KITITITAS COUNTY

MEMORANDUM

TO: All Staff
FROM: Public Works Planning Review Team
DATE: May 21, 2021
SUBJECT: LPF-20-00005 Forest Ridge Final Plat Resubmittal

FOREST RIDGE - PHASE I PERFORMANCE BASED CLUSTER PLAT		
PREPARED FOR FRPP PHASE I, LLC A PORTION OF SECTION 24, TOWNSHIP 20 NORTH, RANGE 15 EAST, W.M.		
KITITAS COUNTY	DATE	JOB NO.
DWN BY T.S.	05/2021	18069
CHKD BY M.K.K./D.L.P.	SCALE 1" = 100'	SHEET 5 OF 7

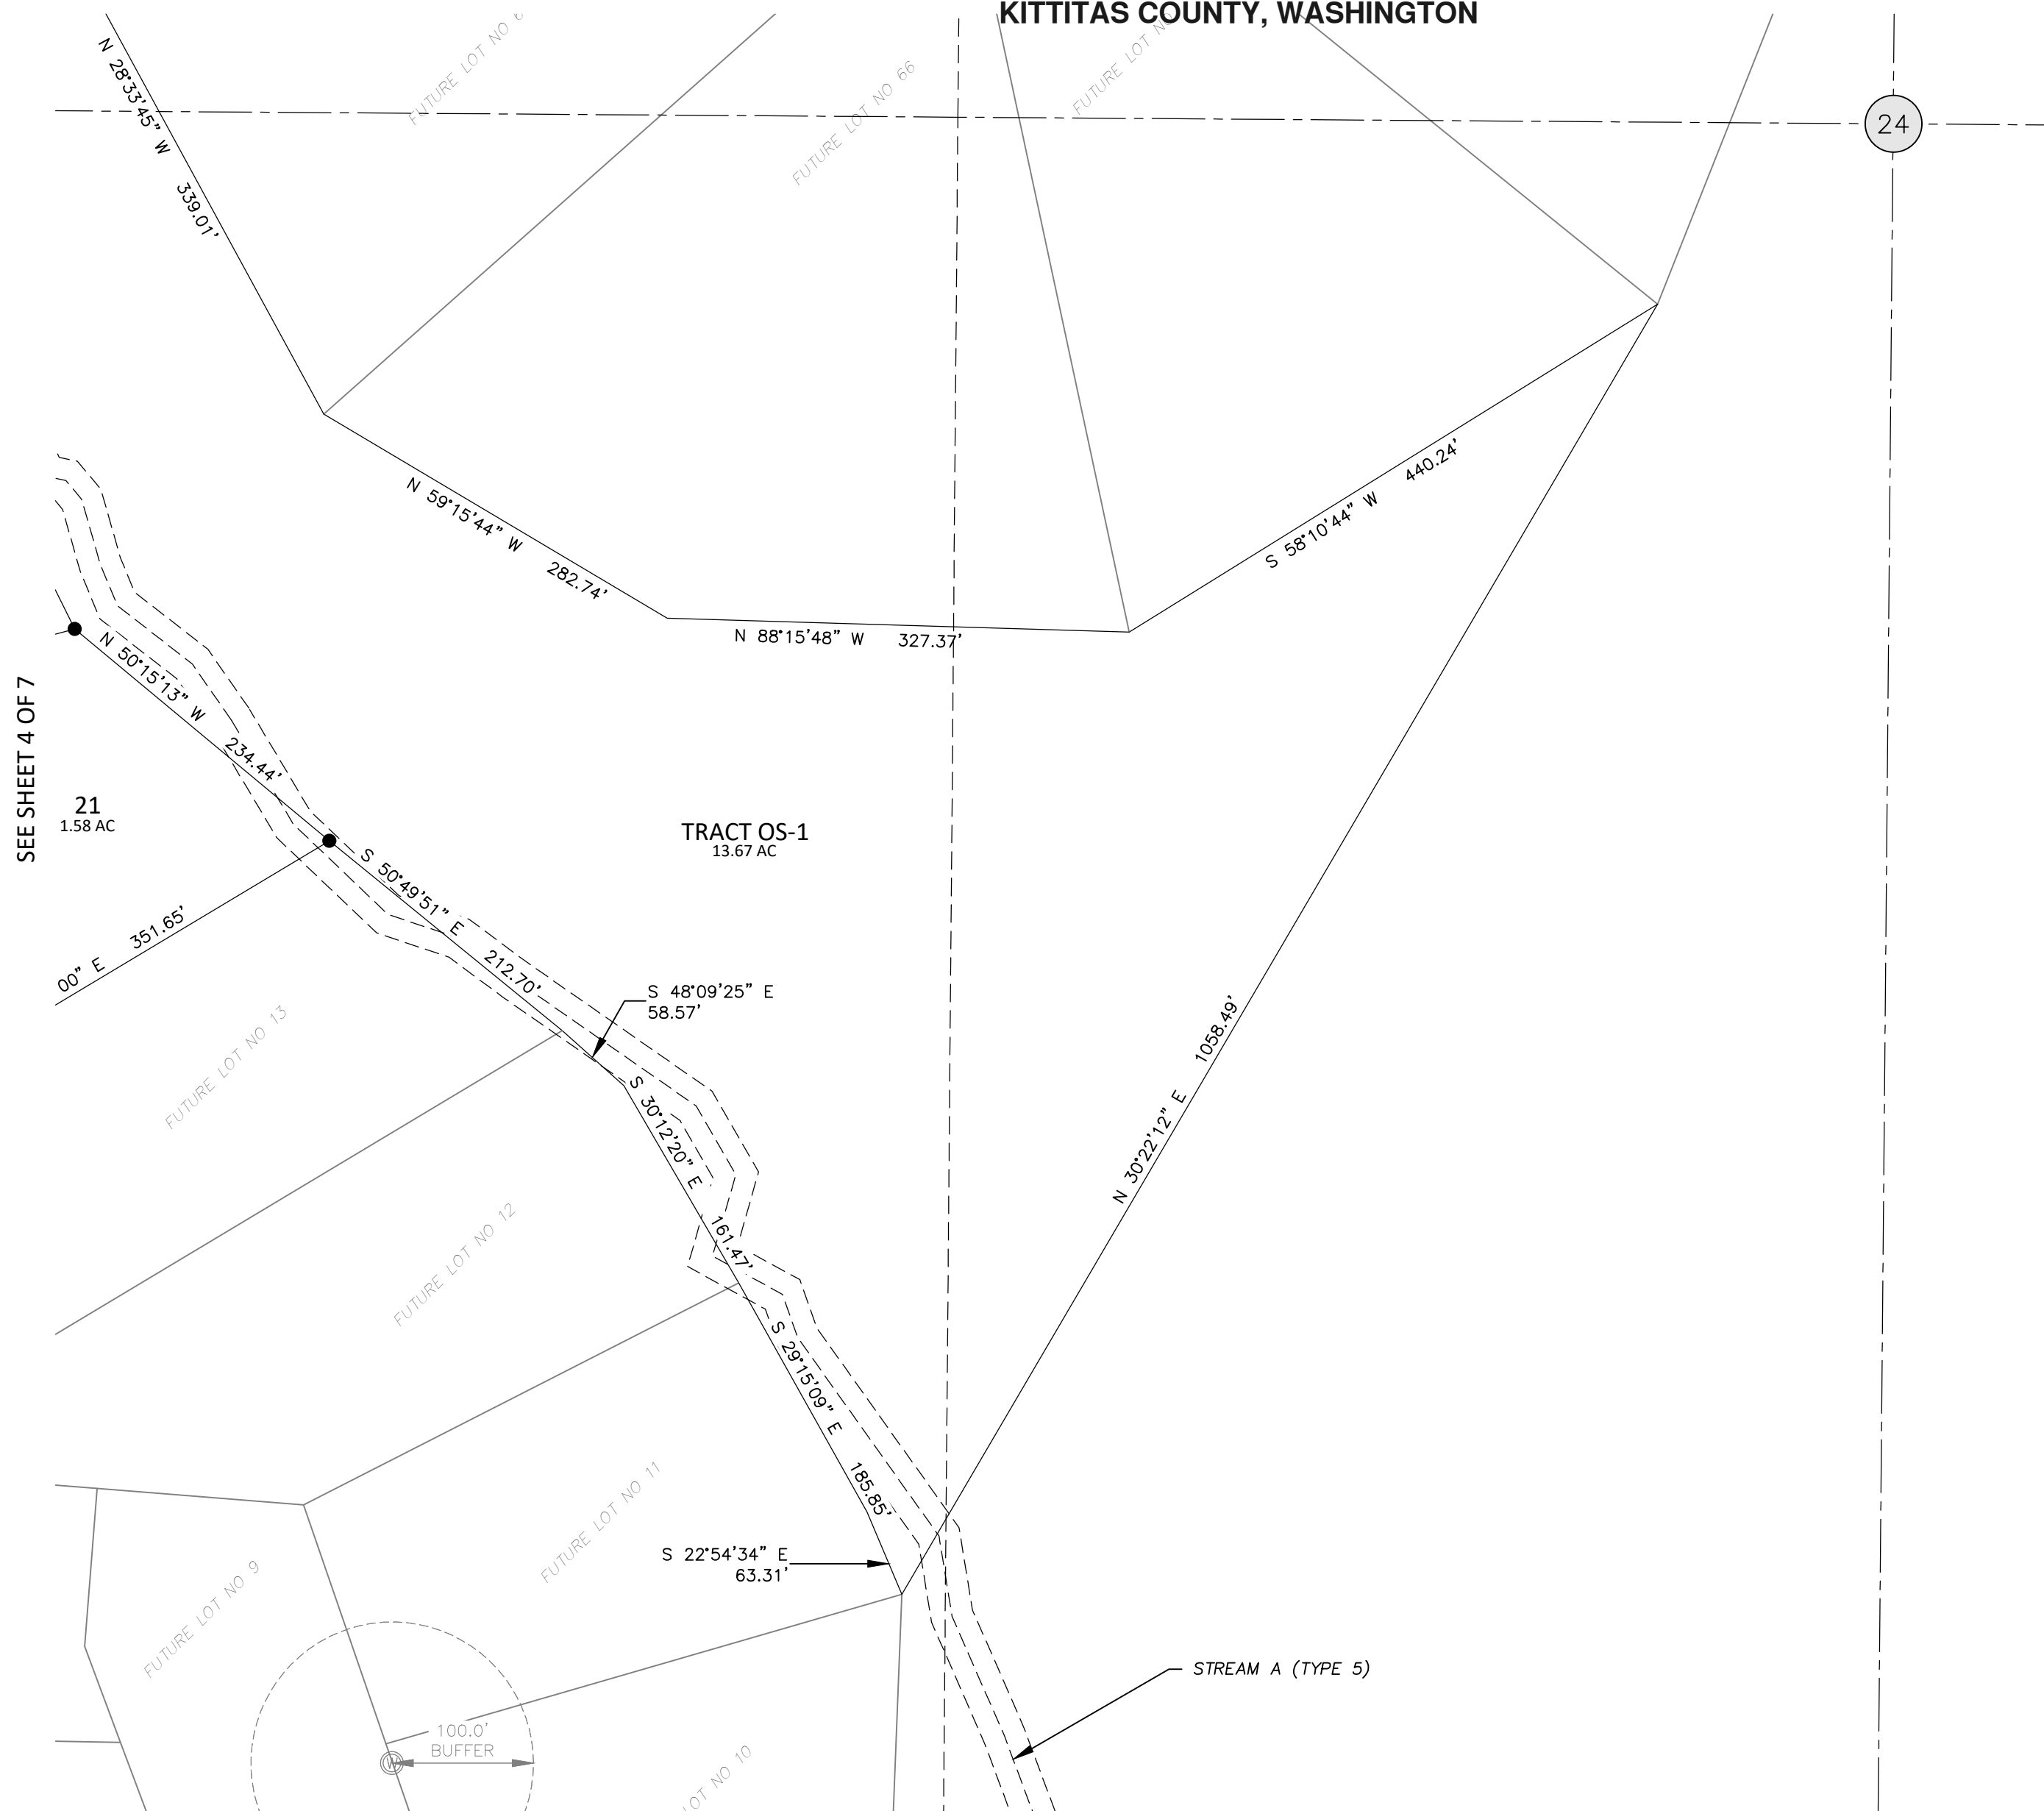
7. Sheet 4 and 5 of 7 references Easement detail sheet 6, for example reference on Tract FD-1. Reference should be to detail sheet 7.
8. Tract AC-1 is identified as Forest Ridge Drive, a private gravel road. KCC 12.12.010 requires a Private Road Maintenance Agreement. If this will be under a home owners association, please include the following note on the face of the plat: *Private Road Tracts, Drainage Pond tracts, Service Tracts, Access Road Tracts, and Open Space tracts are hereby granted and conveyed to the homeowners association upon recording of this plat. Except as otherwise noted, hereon, said Homeowners association is hereby responsible for all maintenance and management obligations associated with said tracts. Should the homeowners association fail to properly maintain said tracts, the owners of all lots of this plat shall be equally responsible for maintenance of said tracts.*

2. All the easements DW-1 through DW-5 and UT-1 through UT-2 incorrectly reference sheet 6 rather than Sheet 7.
3. The dimension of 421.23 at the south end of AC-1 should show 'crows feet' to identify what the dimension is measuring.
4. There are still multiple occurrences of crossing linework obscuring text.
